**MODIFICATION REQUEST:
Residential and Child Care Centre
Development
14-18 Boondah Road Warriewood
MP10_0177 MOD 9**

Director-General's
Environmental Assessment Report
Section 75W of the
Environmental Planning and Assessment Act 1979

July 2012

SOUTH ELEVATION
BLOCK E

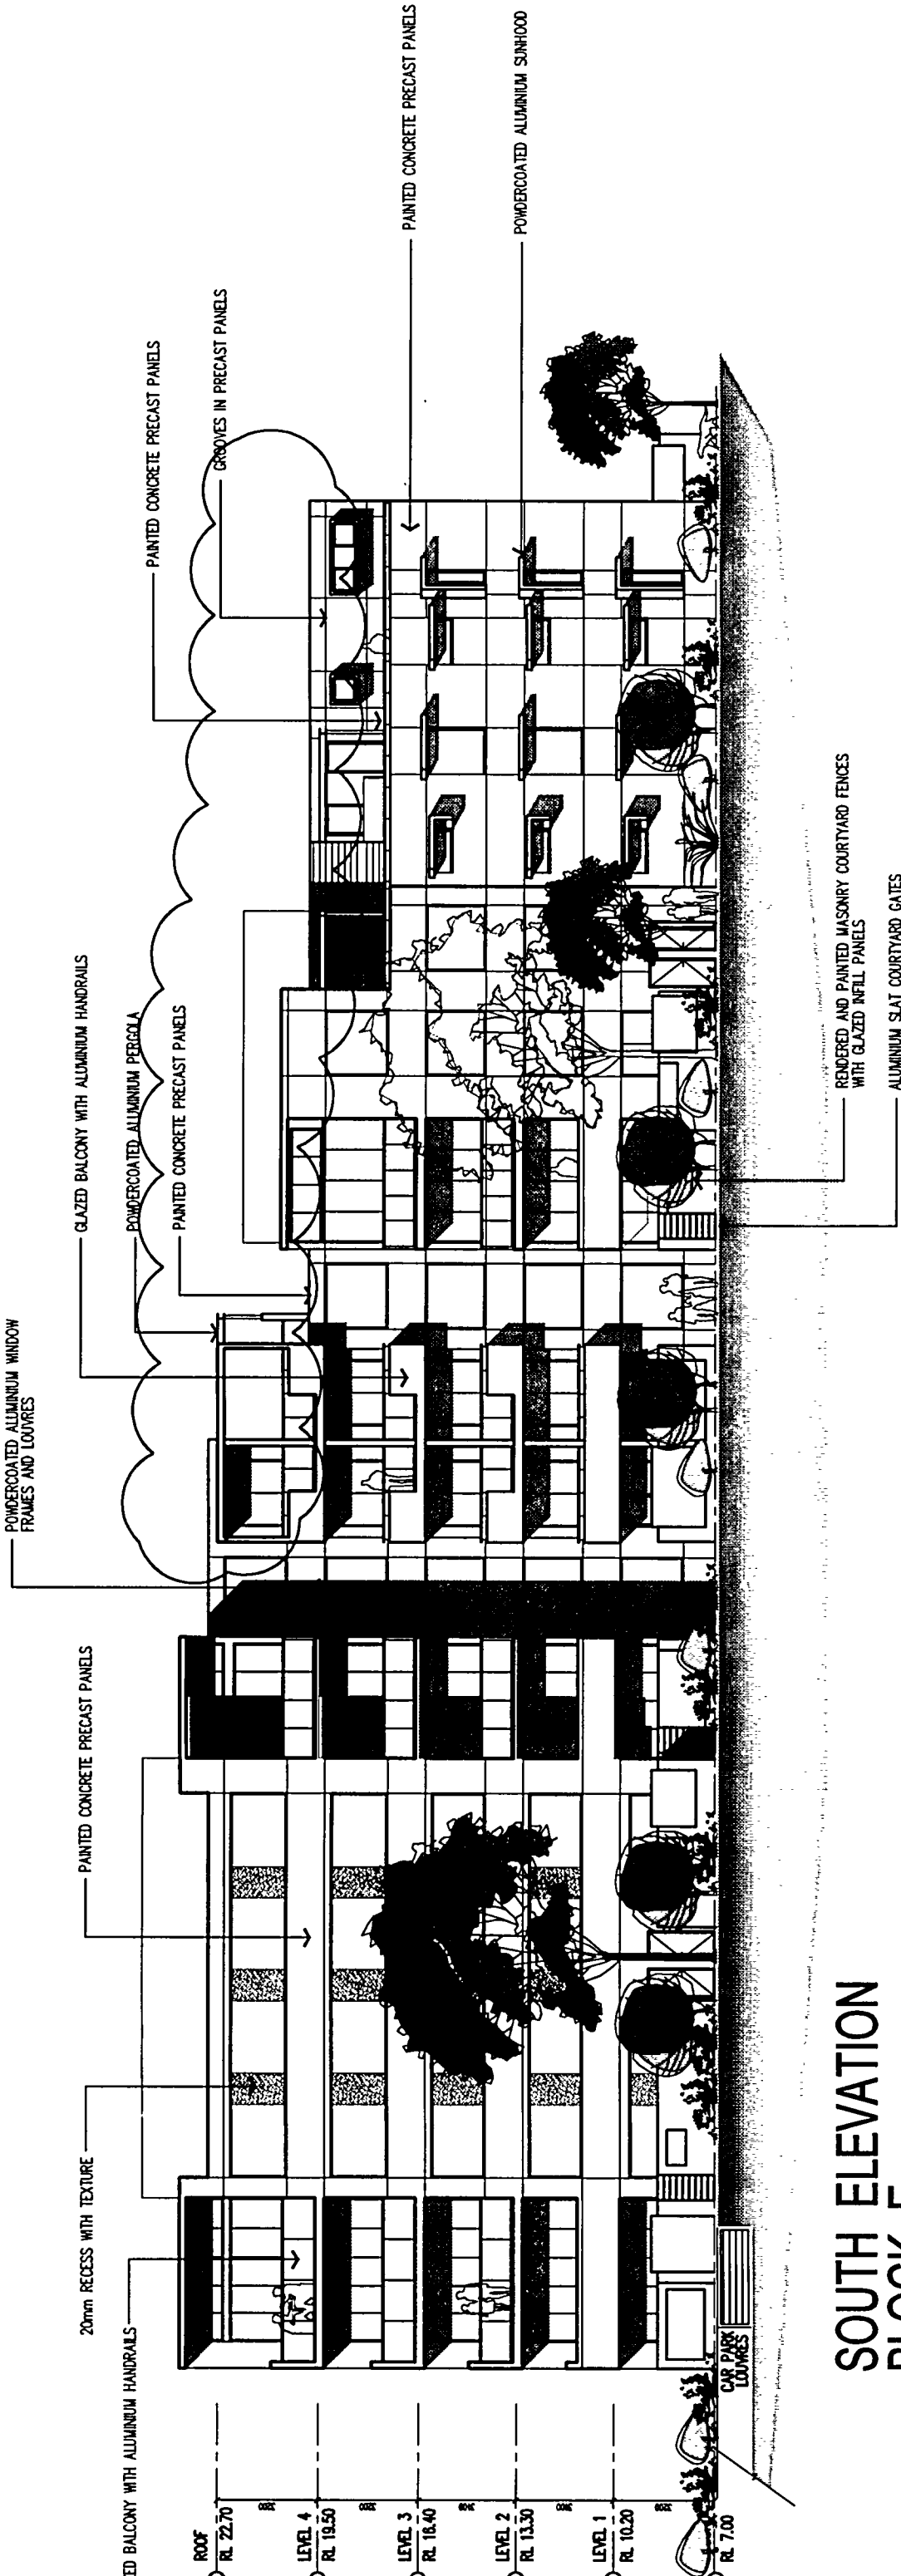
The proposed extension of the roof slab to Building G serves to provide shade to a terrace of Unit 330. The impact of this design change is considered to be negligible to the overall bulk and scale of the building given the projection of the roof slab and that it covers a relatively small area of approximately 12m². Furthermore, the proposed roof slab does not project above the height of the building and maintains uniformity with other horizontal façade treatments which include awnings and pergolas.

Figure 5 depicts the extent of the proposed roof slab extension and its appearance on the south elevation of the building.

The Department raises no issue with the proposed 'pop-up' roofs and the extension of the roof slab to Building G and E as the impact on bulk and scale is considered negligible and they are consistent with existing design elements of the buildings.
